April 20, 2022

Gareth Reece
Senior Plans Examiner
City of Mercer Island Community Planning and Development

RE: Permit 2109-150 Correction Comment Responses
Site Address: 9611 SE 72nd Street

A411

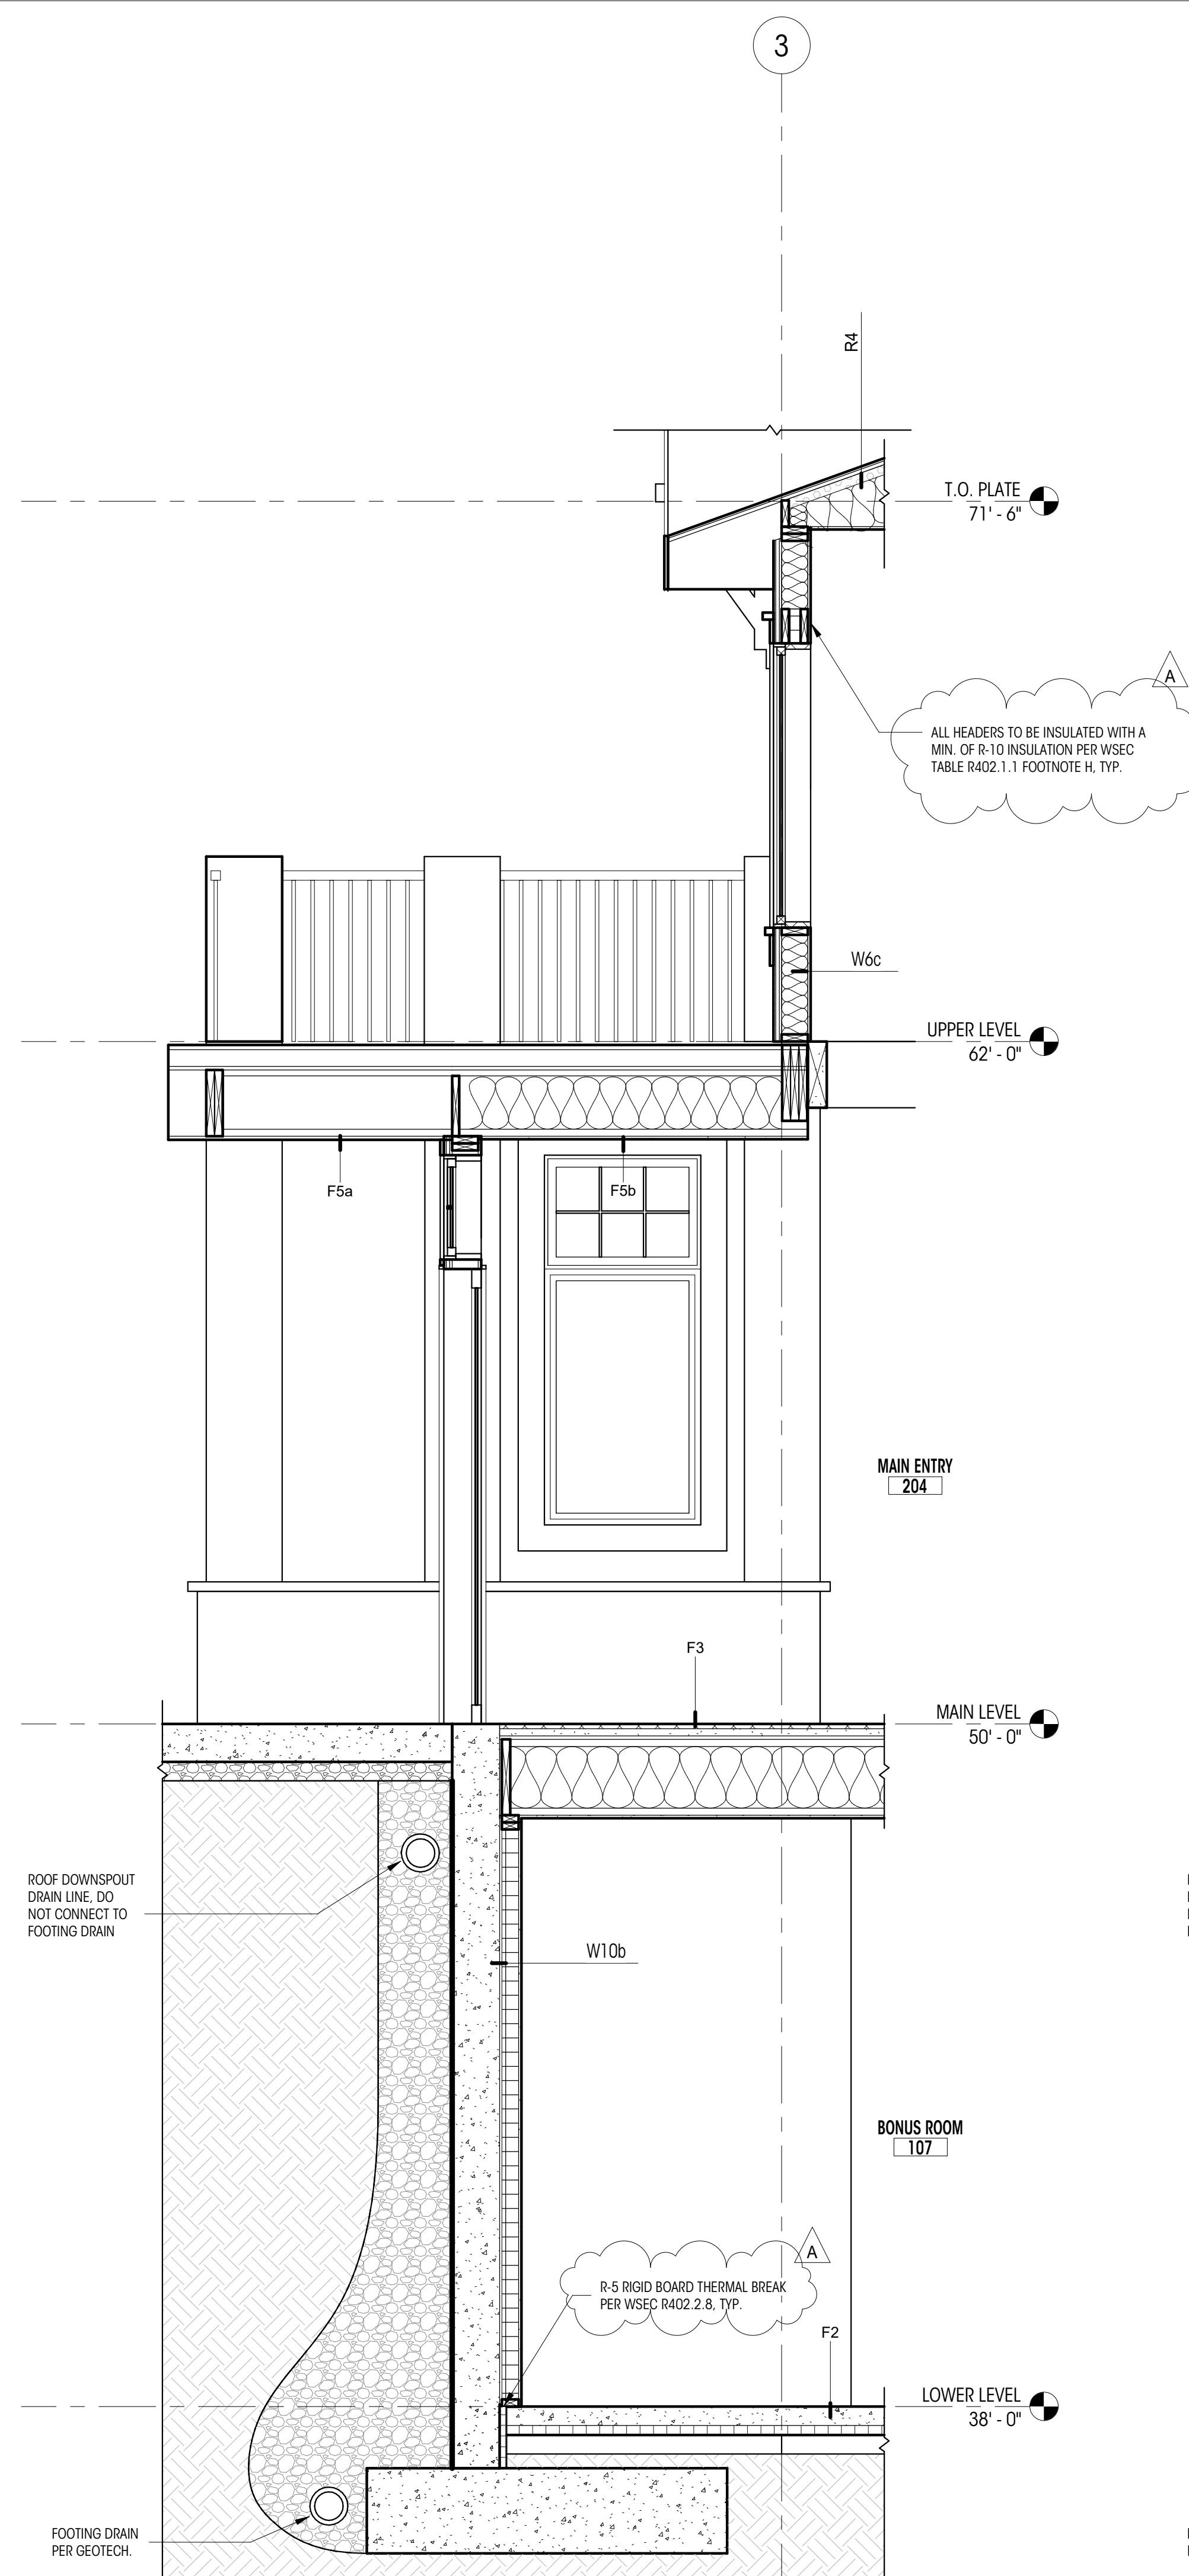
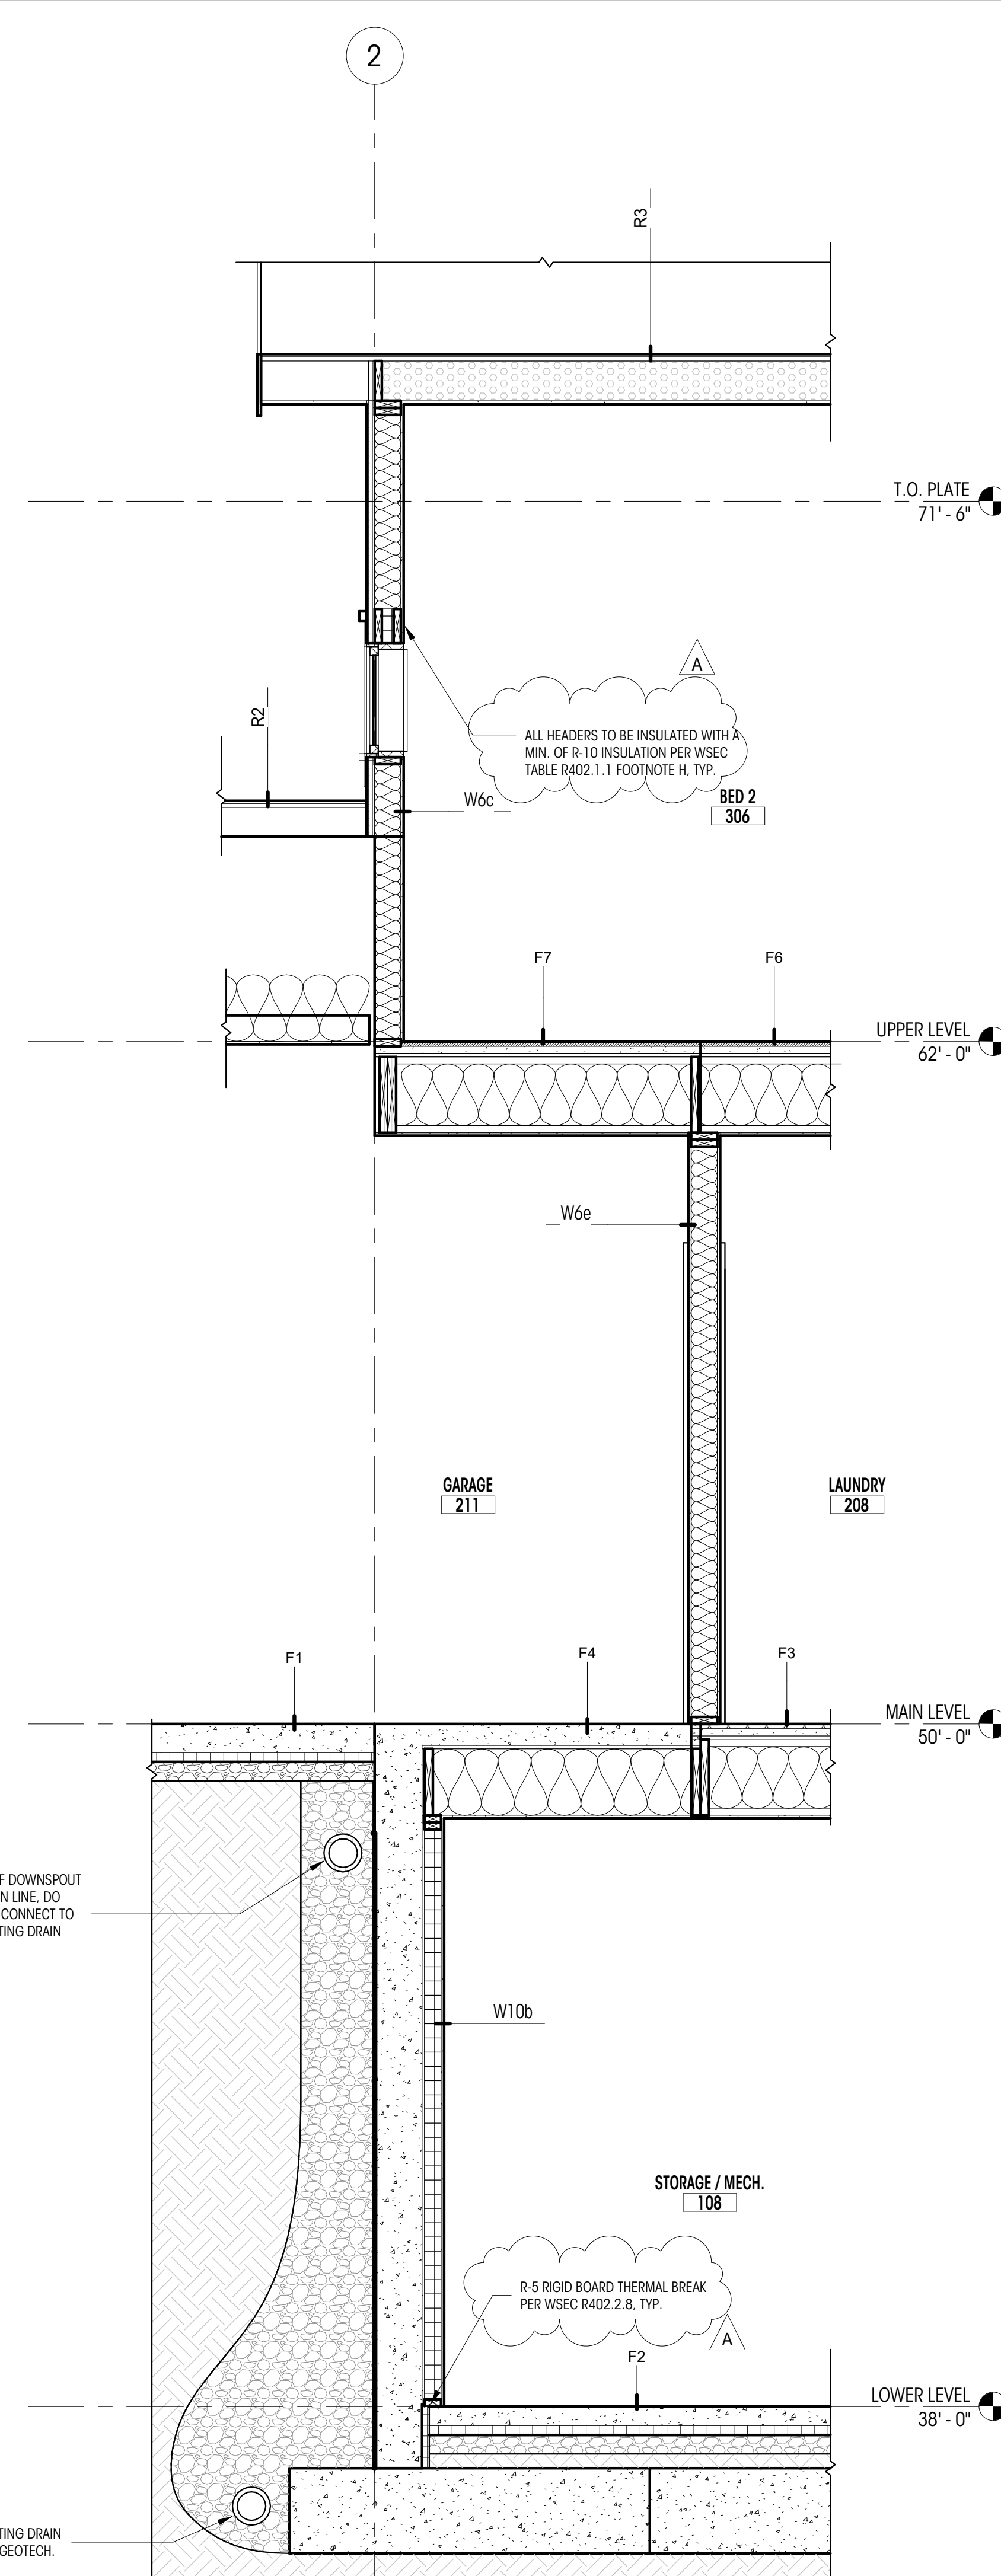
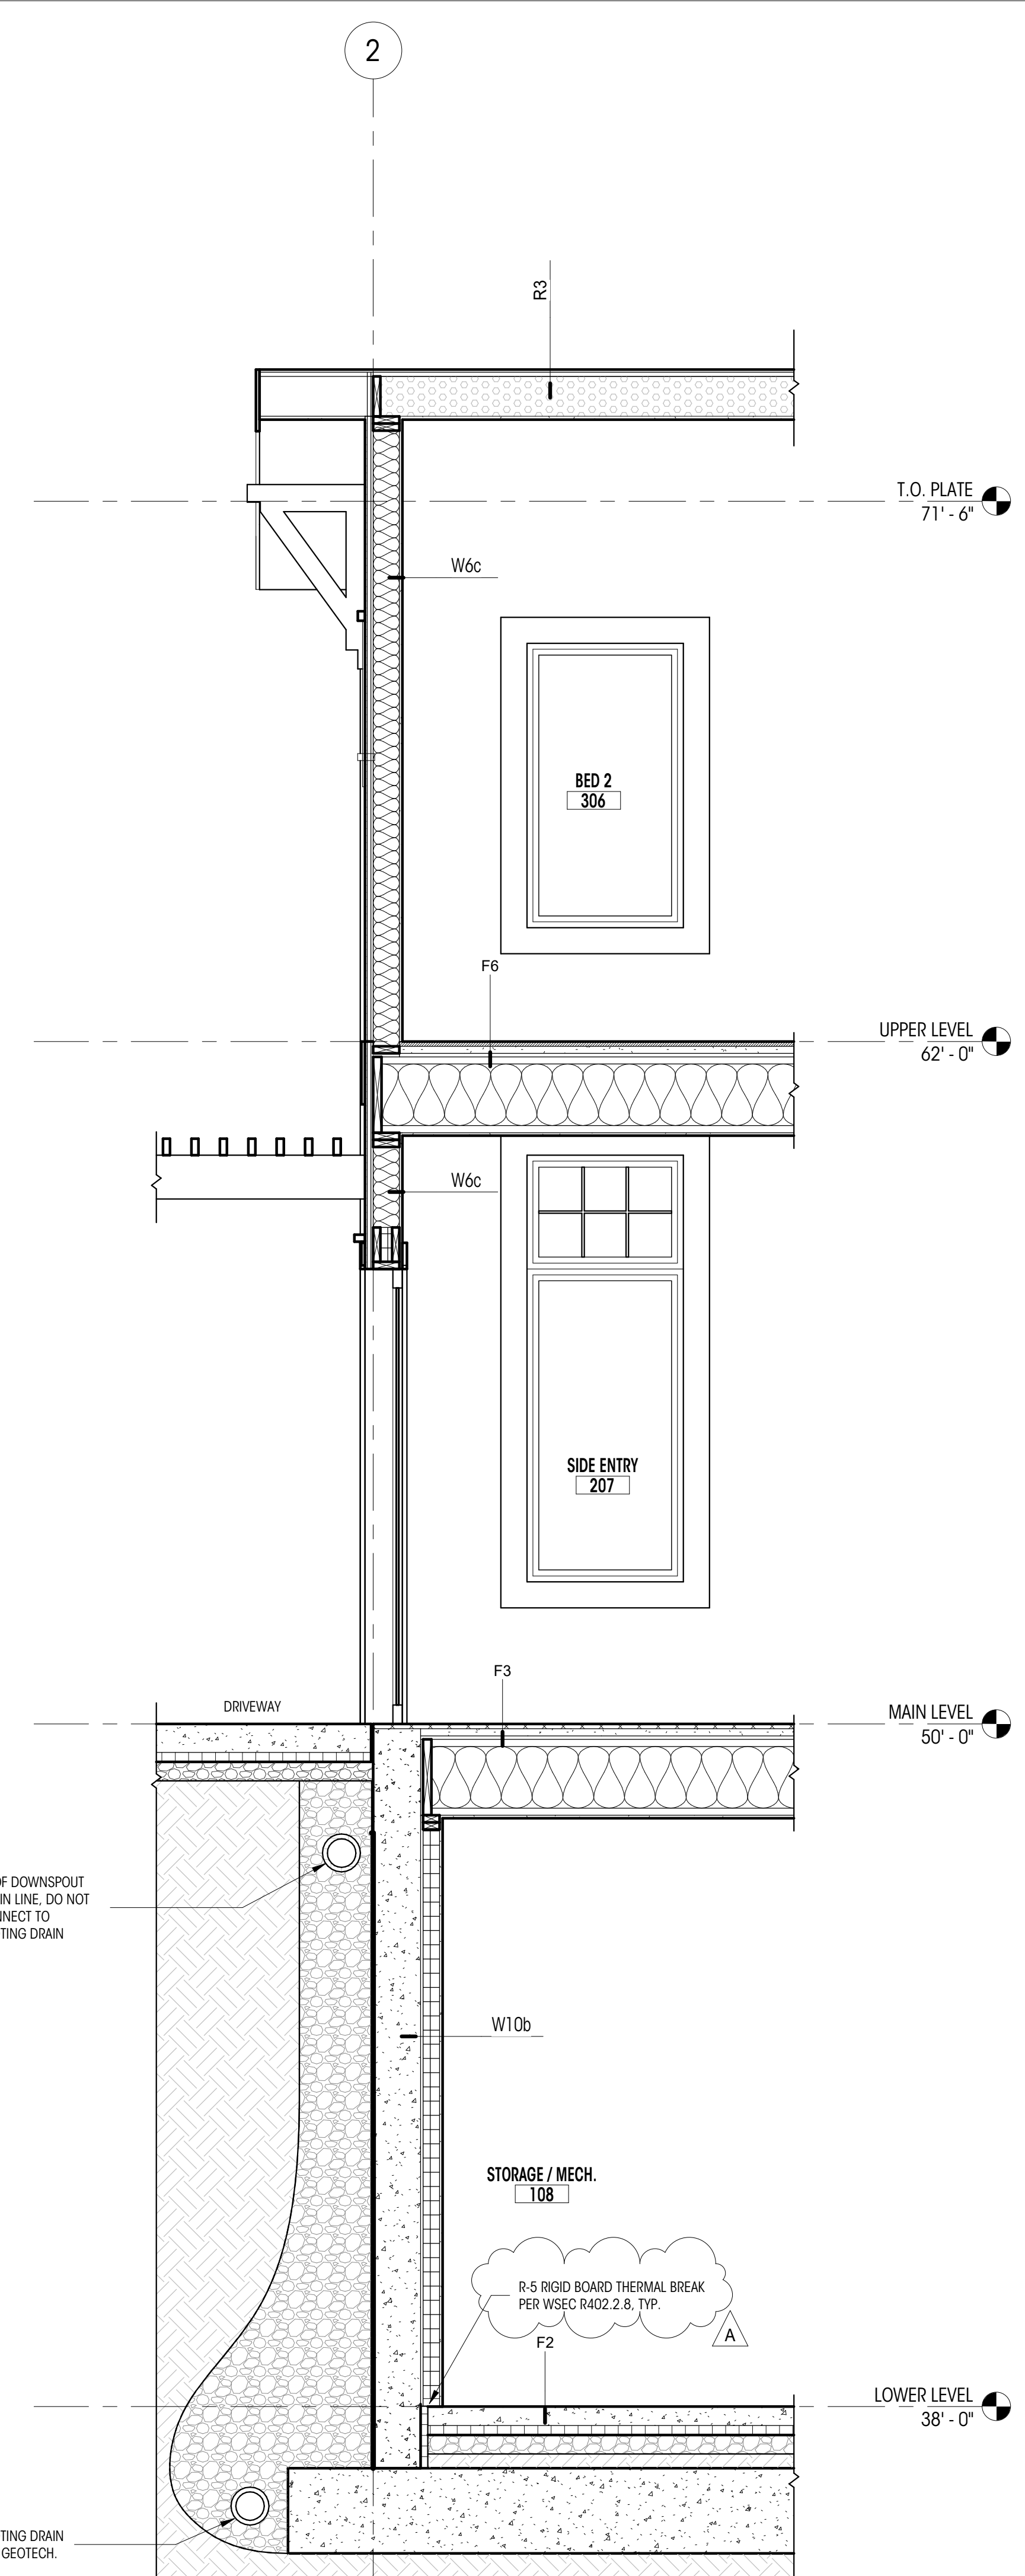
10. Intermediate framing at wood walls requires headers insulated to a minimum of R-10 per WSEC Table R402.1.1 footnote h. Call for headers insulated with R-10 on the drawings.

Response: Notes have been added to applicable wall sections 1 and 2 on sheet A411.
